23 November 2010

**Major Project 10_0107 – Residential Development – Buildings 1, 2 & 3
61 Mobbs Lane - Epping - Channel 7 Site (Epping Park)**

EPPING PARK, BUILDINGS 1 & 2
61 MOBBS LANE, EPPING
LANDSCAPE CONCEPT PLAN

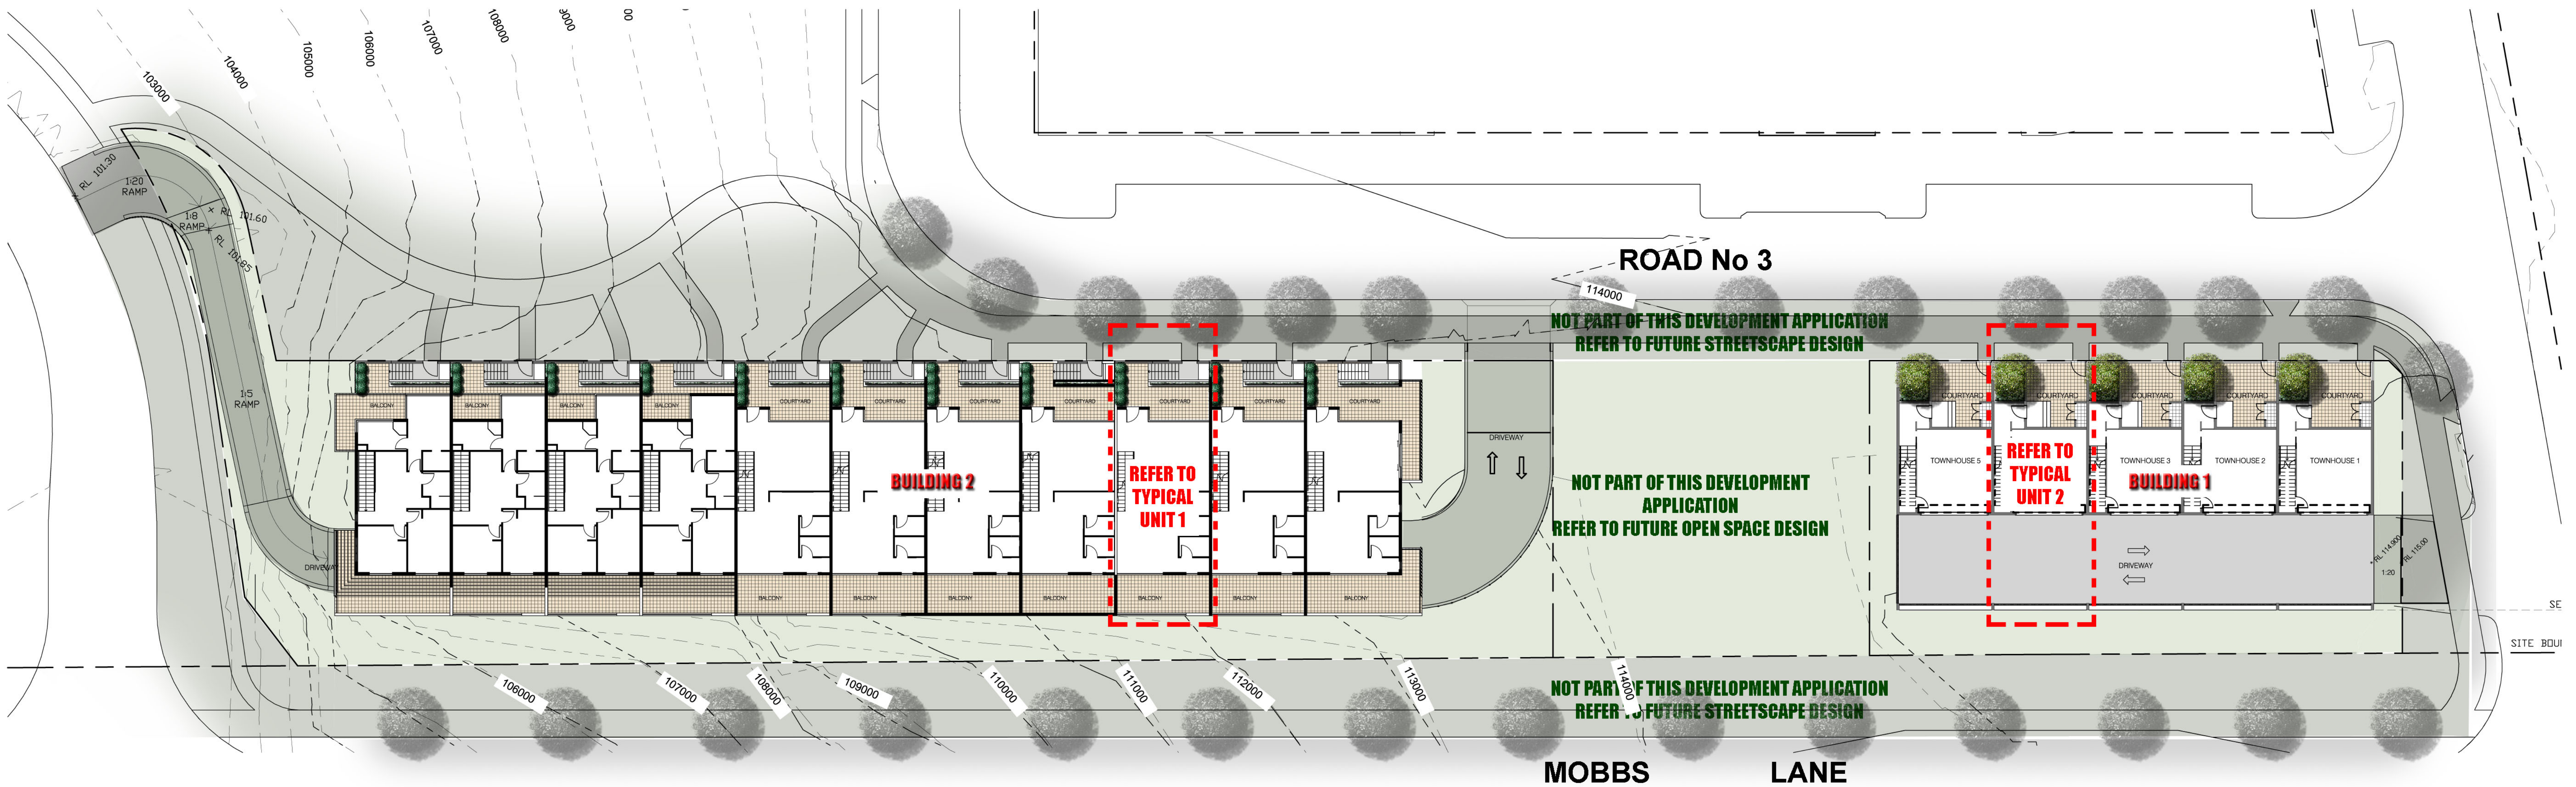
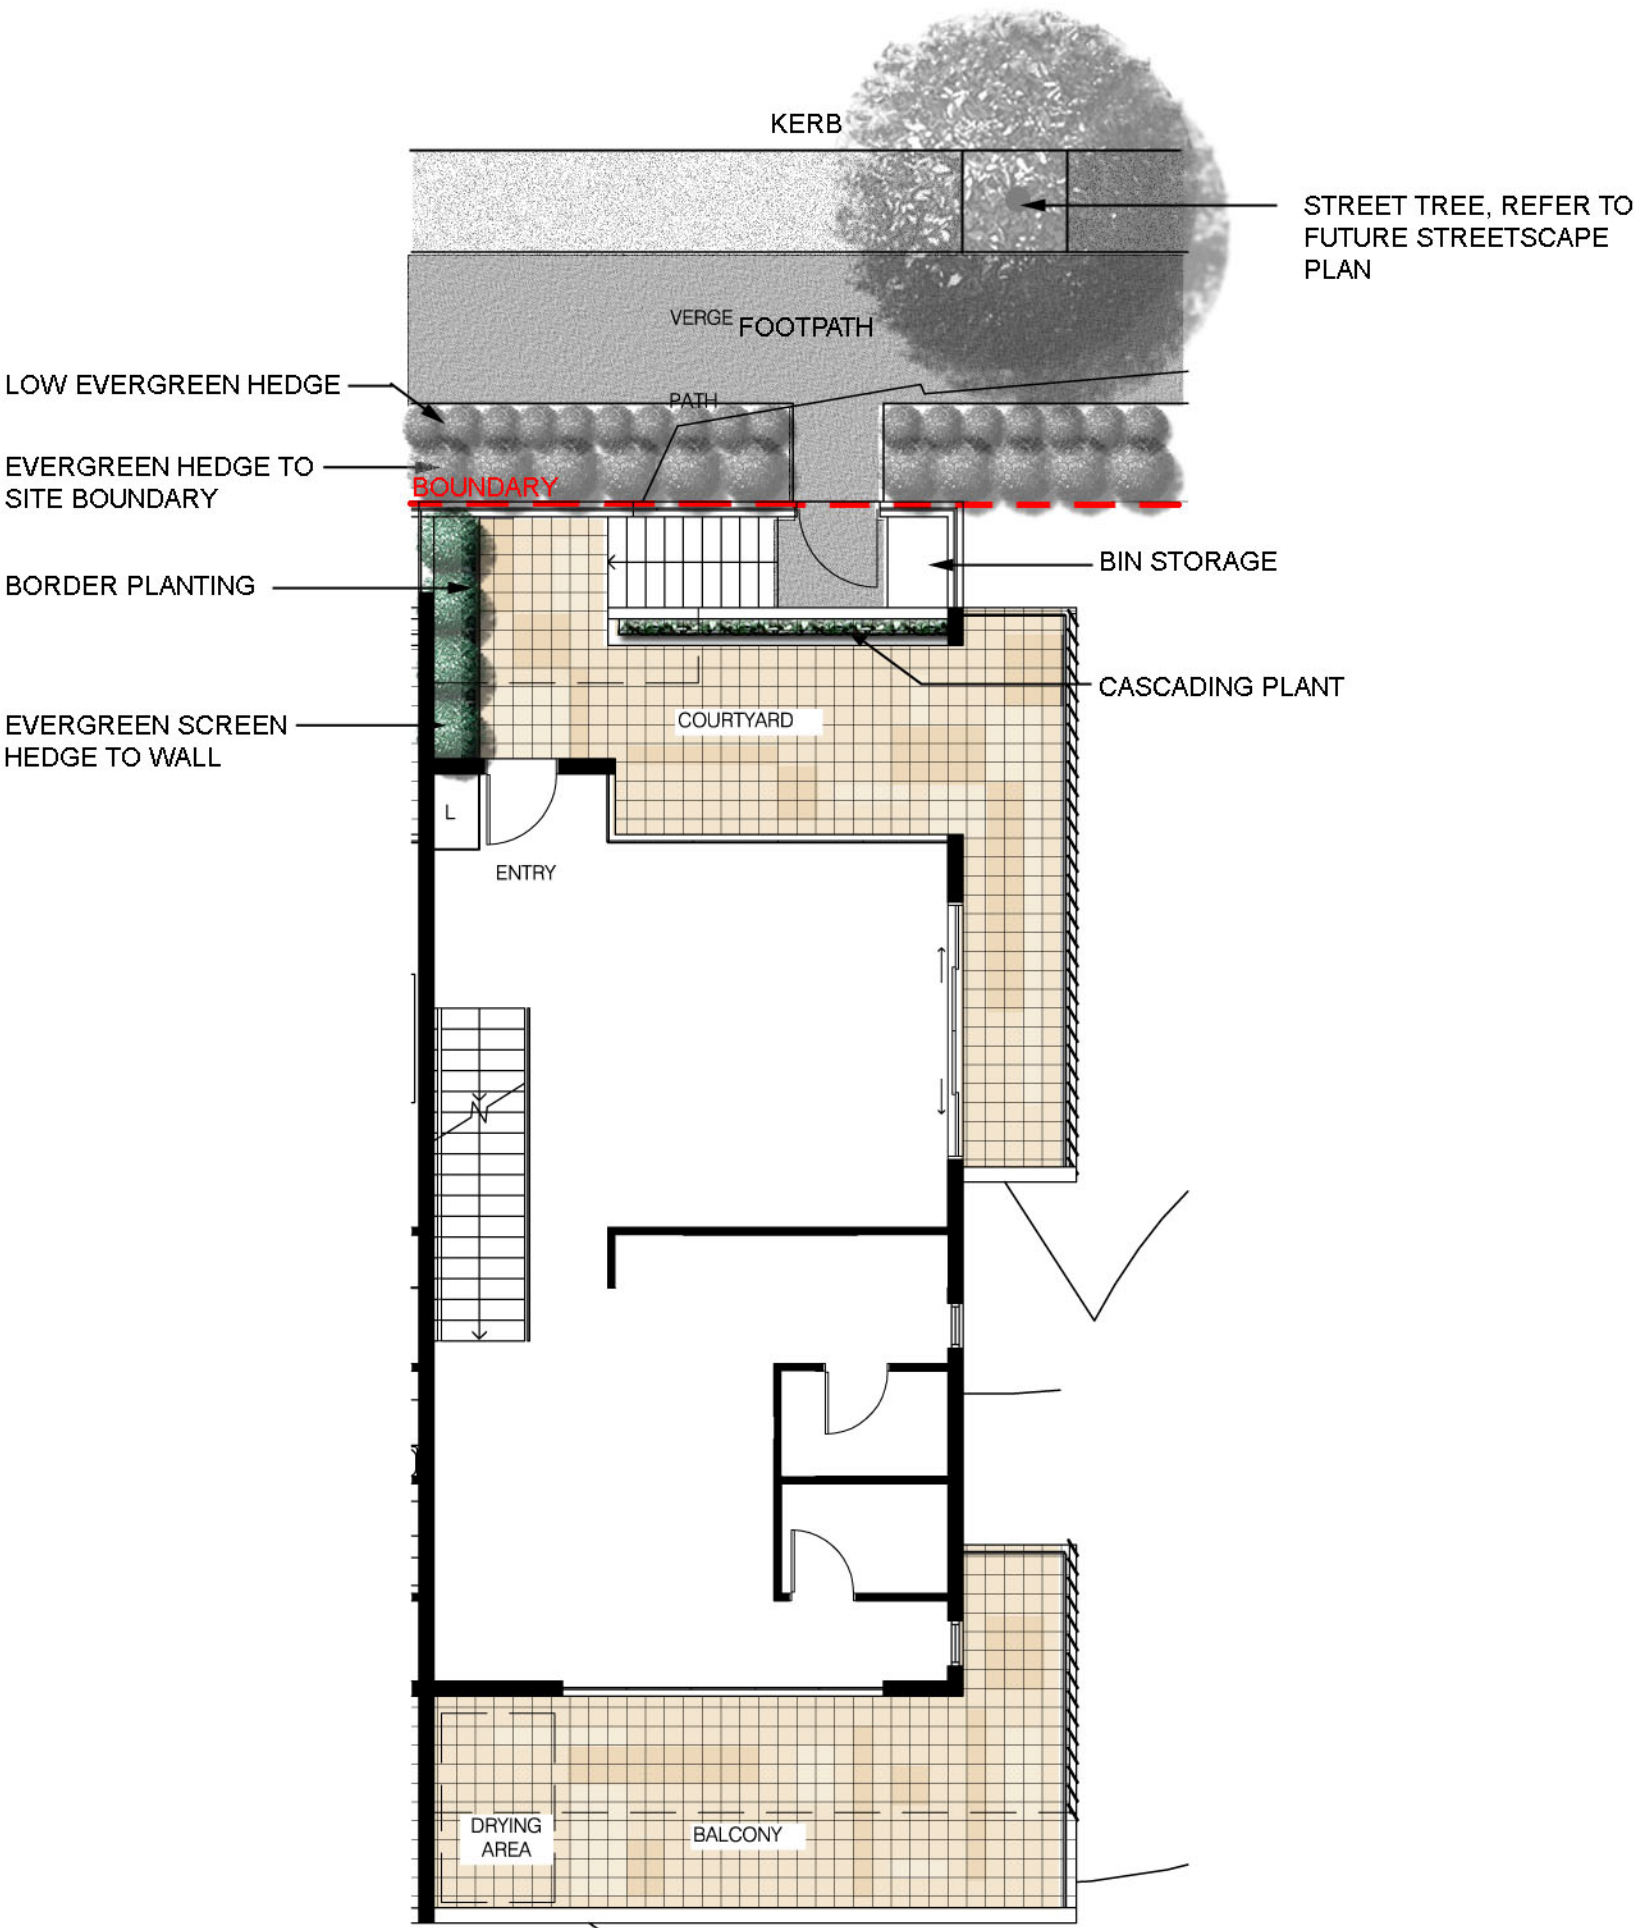
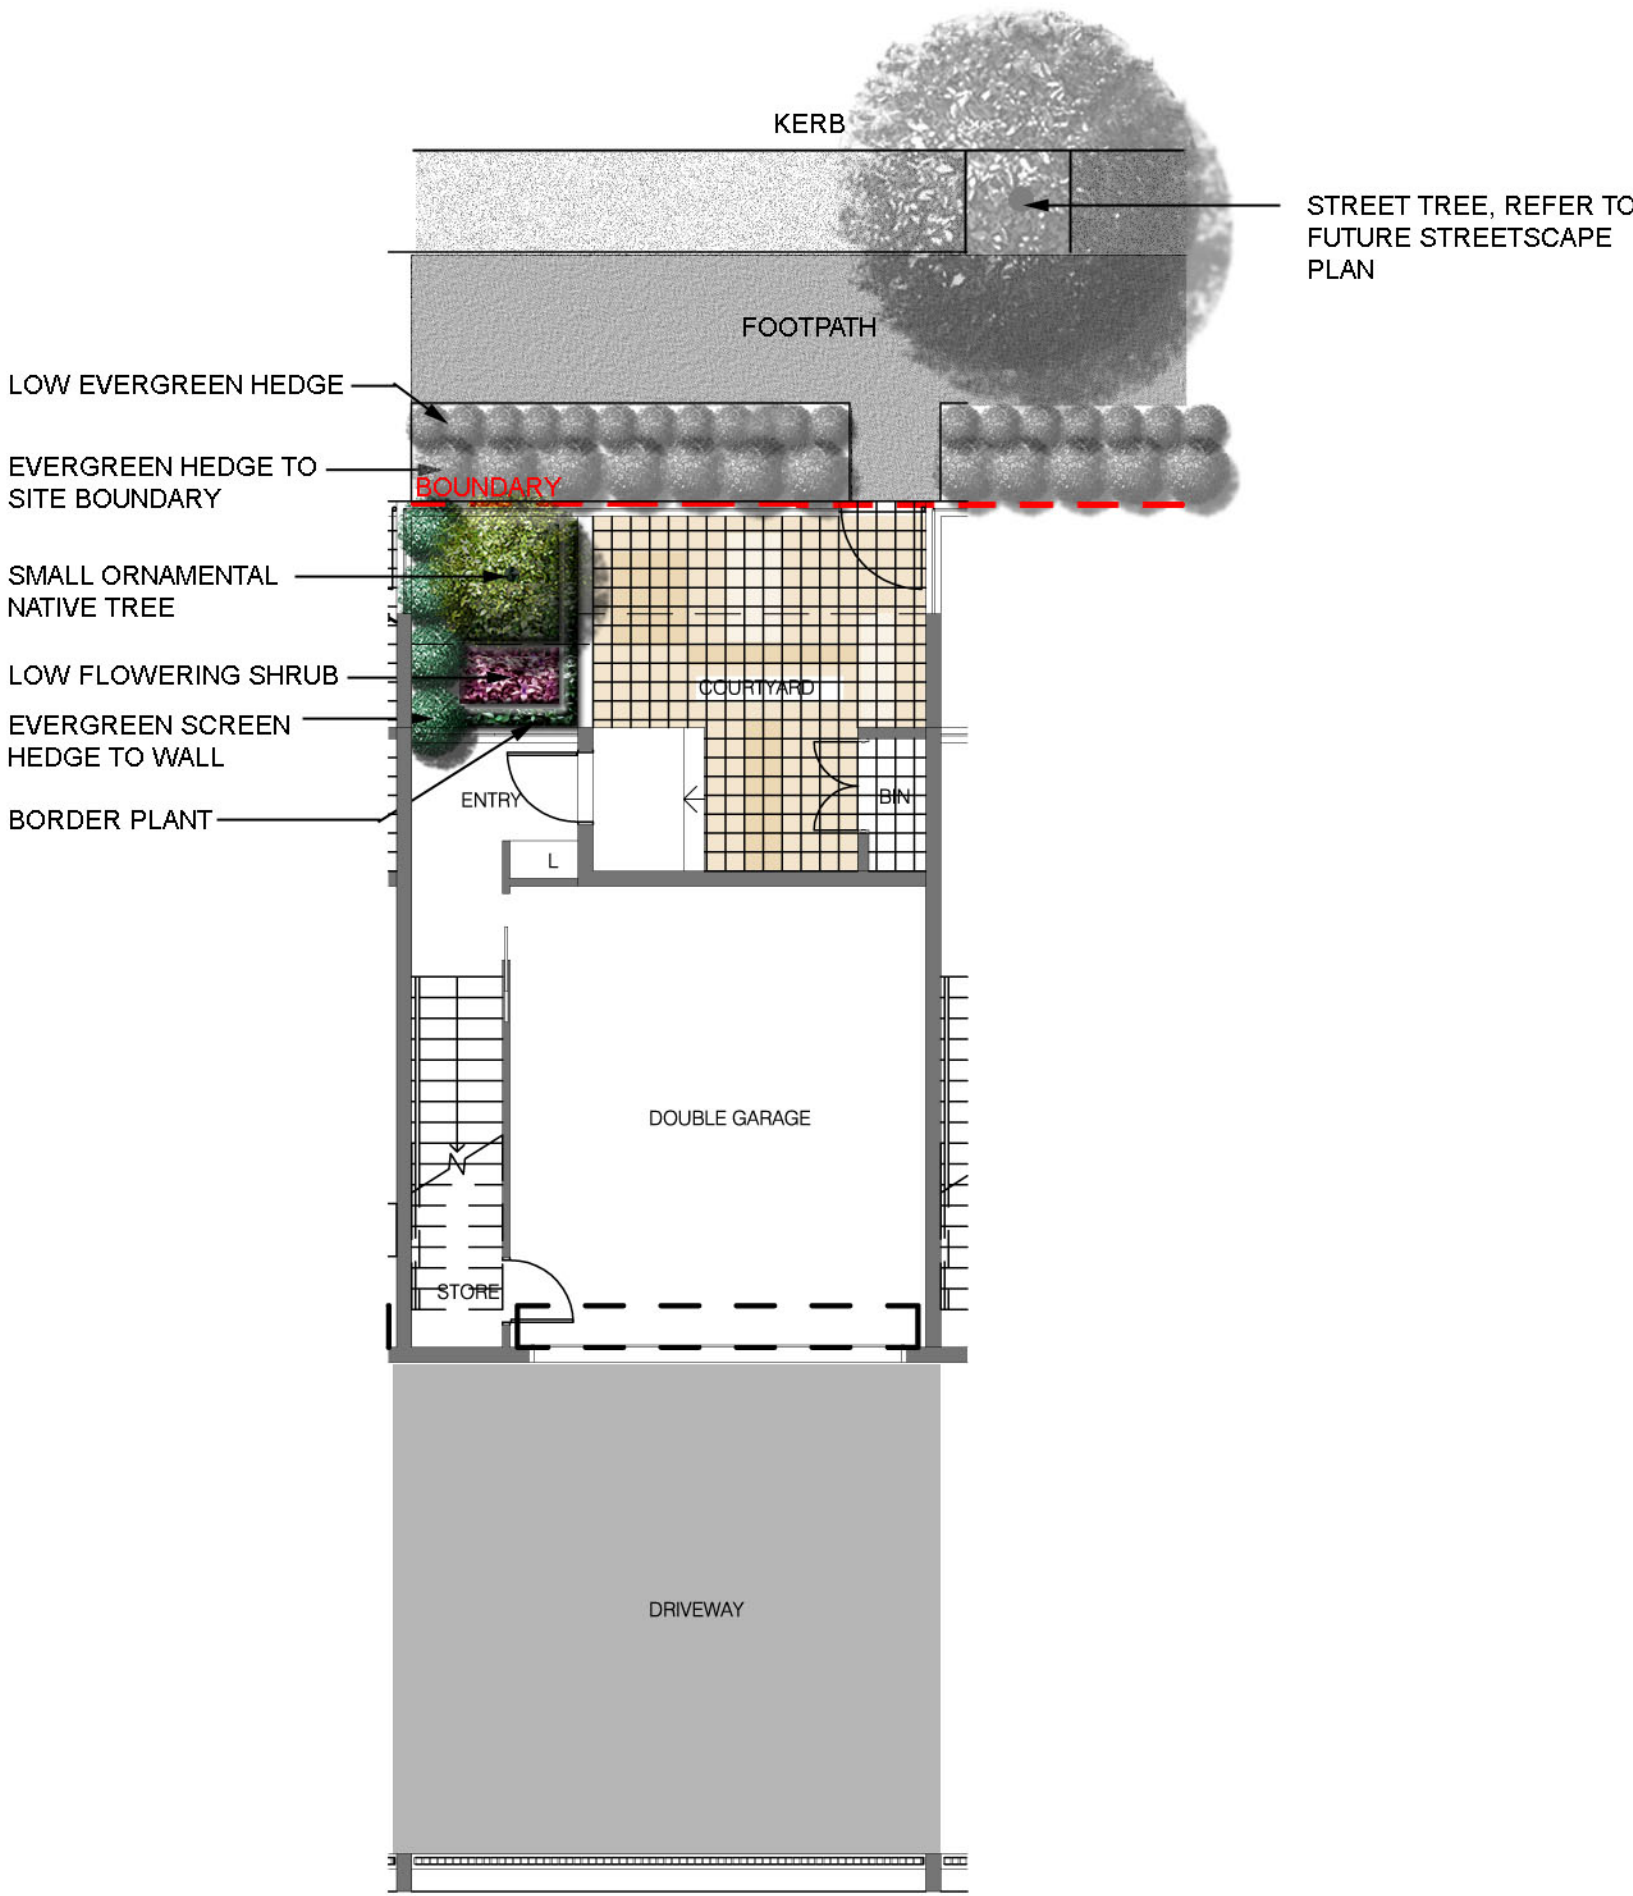
Townhouses generally provide private open space at natural ground level and Parramatta Development Control Plan 2005 requires a minimum provision of 40m² per dwelling. Front yards should not be considered or used as private open space as they are semi-private areas. Fencing should be reduced in height to provide a better integration with the public domain of the internal circulation spaces. A maximum fence height of 1.2m should be permitted with no more than 900mm from natural ground level being solid and the remainder semi transparent.

The Concept Plan indicates a 6m setback to Mobbs Lane. The proposal separates this into a landscaped setback up to 3.6m wide from Mobbs Lane and a 3m wide partially submerged driveway and balcony on top. A 3m setback is not consistent with the character of the area. Parramatta Development Control Plan 2005 requires a front setback between 5m and 9m, which is more consistent with the approved Concept Plan than the application. Front setbacks of 3m are more conducive to secondary setbacks rather than primary setbacks. The proposal should be amended to comply with the setback requirements of the Concept Plan to enable a reasonable setback to Mobbs Lane and the ability to provide sufficient deep soil zones for landscaping along the frontage.
